**From:** Patel, Uday <Uday.Patel@lancashire.gov.uk>  
**Sent:** 13 October 2014 11:13  
**To:** planning  
**Subject:** 3/2014/0791

Planning Application Reference: 3/2014/0791

LOCATION PLAN. ASHTREE COTTAGE

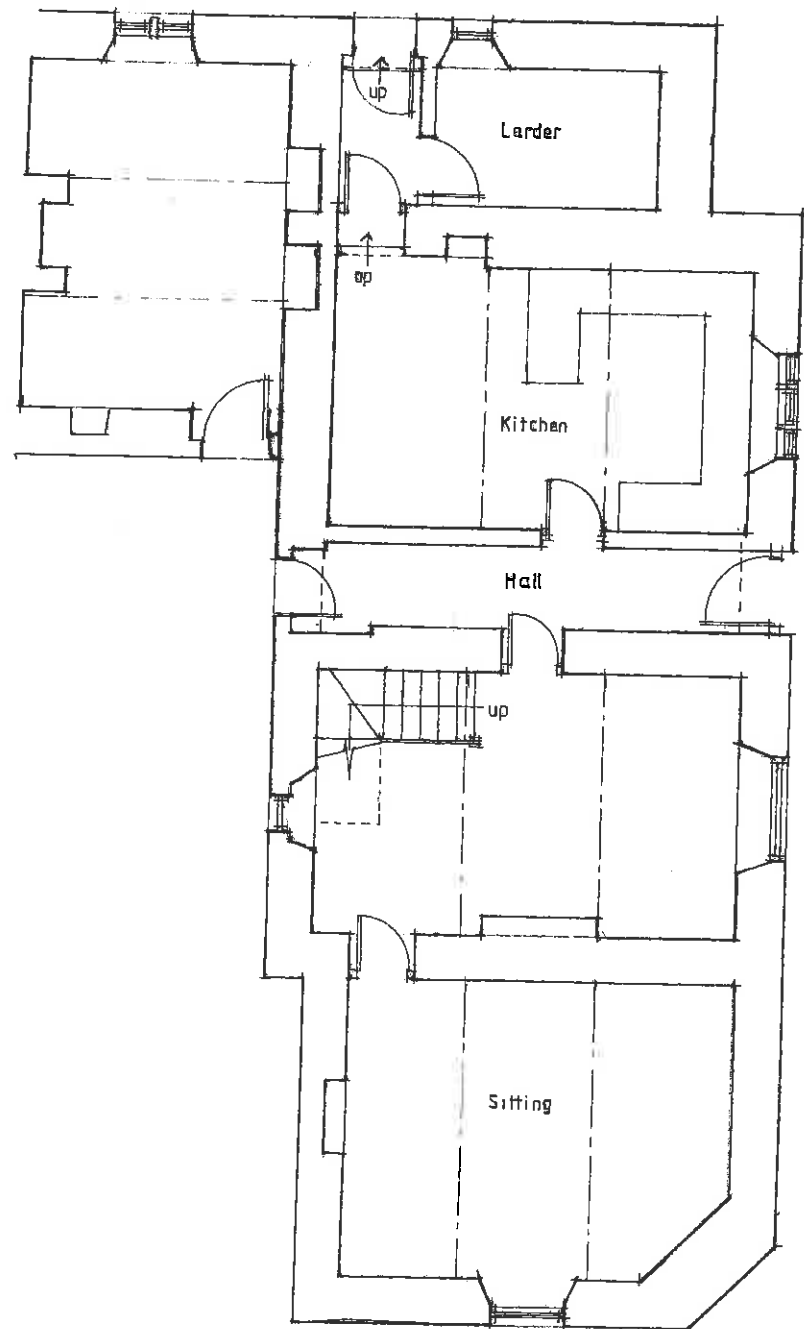
1. Application form indicates 4no parking provision for proposed 4no letting bedrooms.
2. Please provide the layout plan indicating above provision of 4no parking places for proposed development.
3. Please clarify: Highways point of view adjacent car park to the proposed development is used by the general public including the residents of the nearby properties. This car park also is used for the PH. It is realised that existing parking places is already overstretched in the existing car park. Is the existing car park to be used for the parking of 4no vehicles associated with the proposed development?
